June 7, 2019

RE: Mark 3S Holly Development NIDO (BP-2018-06278)
9300 Holly Ave NE
Request for Certificate of Occupancy – Temporary
Engineer’s Certification – Accepted
Engineer’s Stamp Date: 3/8/18
Certification Dated: 6/7/19
Hydrology File: C20D062

RE: Mark 3S Holly Development NIDO (C20/D062)

**GRADING AND DRAINAGE PLAN
MARK 3S HOLLY DEVELOPMENT**

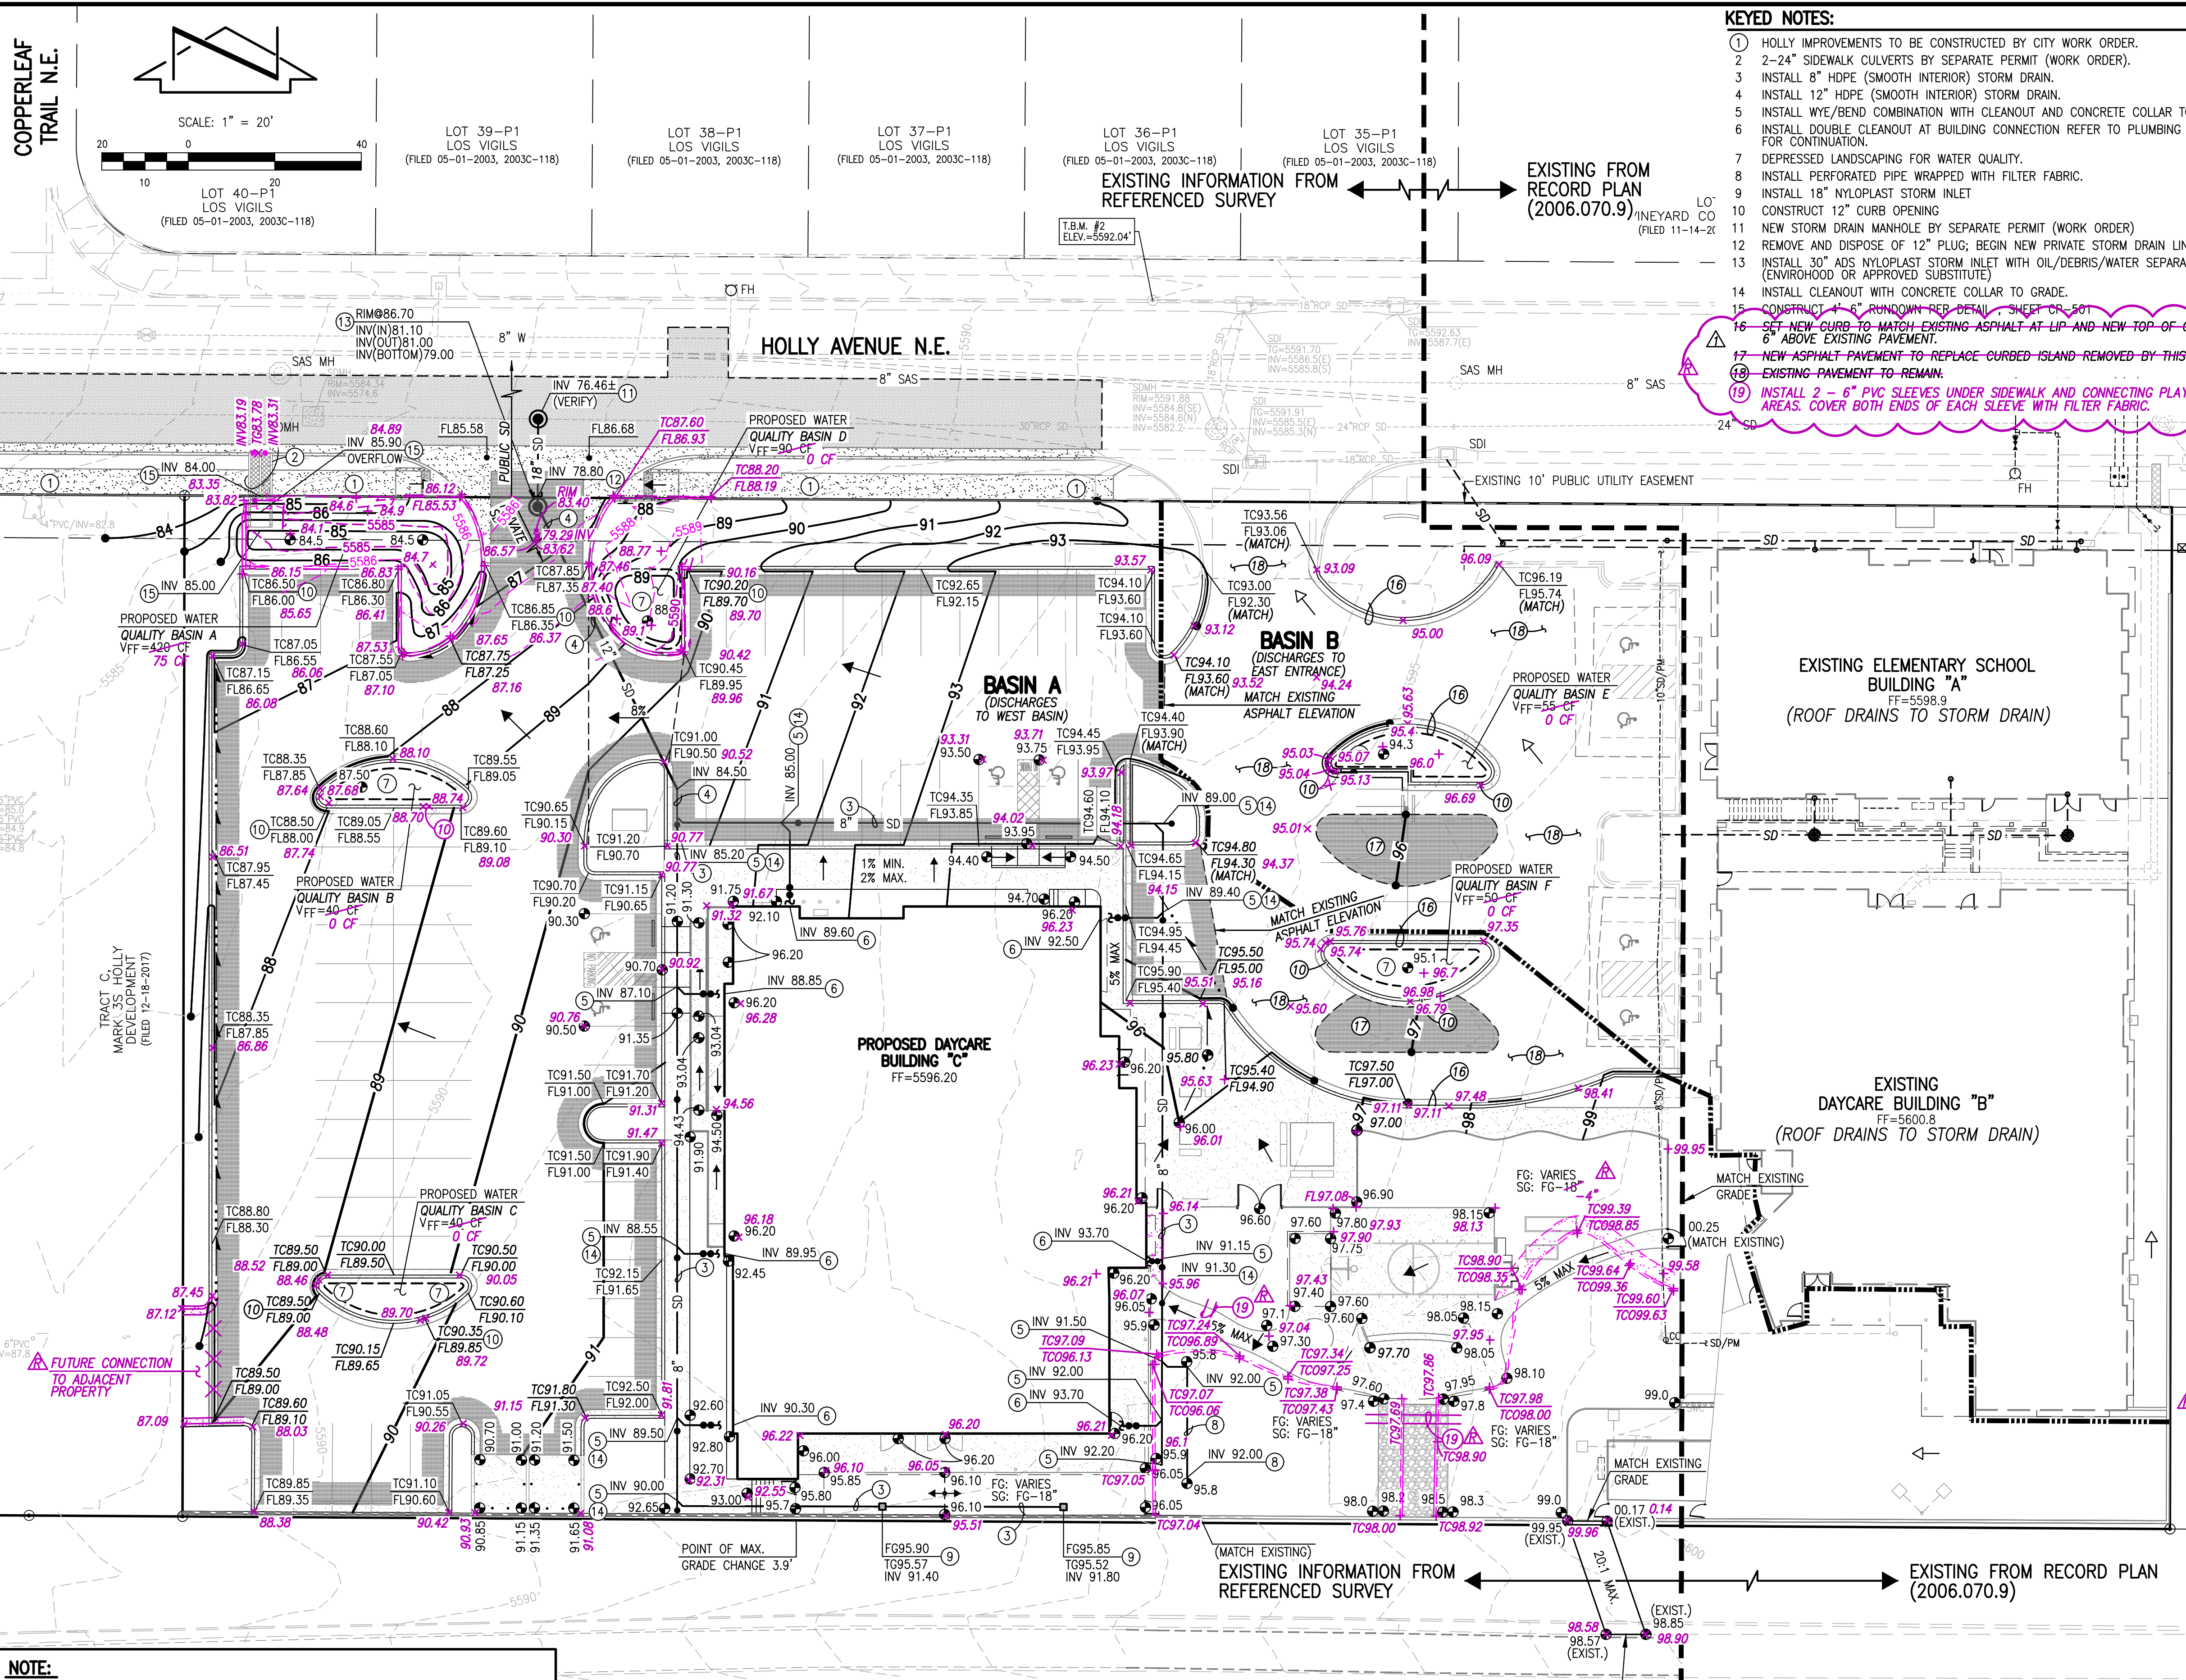
3. The east playground construction needs to be completed and verified for final certification.
4. The northwest pond was under construction at the time of visit and needs to be completed and verified for final certification.

5. It is anticipated that the total water quality volume set by approved design will not be met. The owner has elected to make a payment in lieu of meeting this volume. The total water quality volume provided by the site will be verified with the final certification of the site.

In addition to the items above, it is anticipated that the total water quality volume set by approved design will not be met. The owner has elected to make a payment in lieu of meeting this volume. The total water quality volume provided by the site will be verified with the final certification of the site.
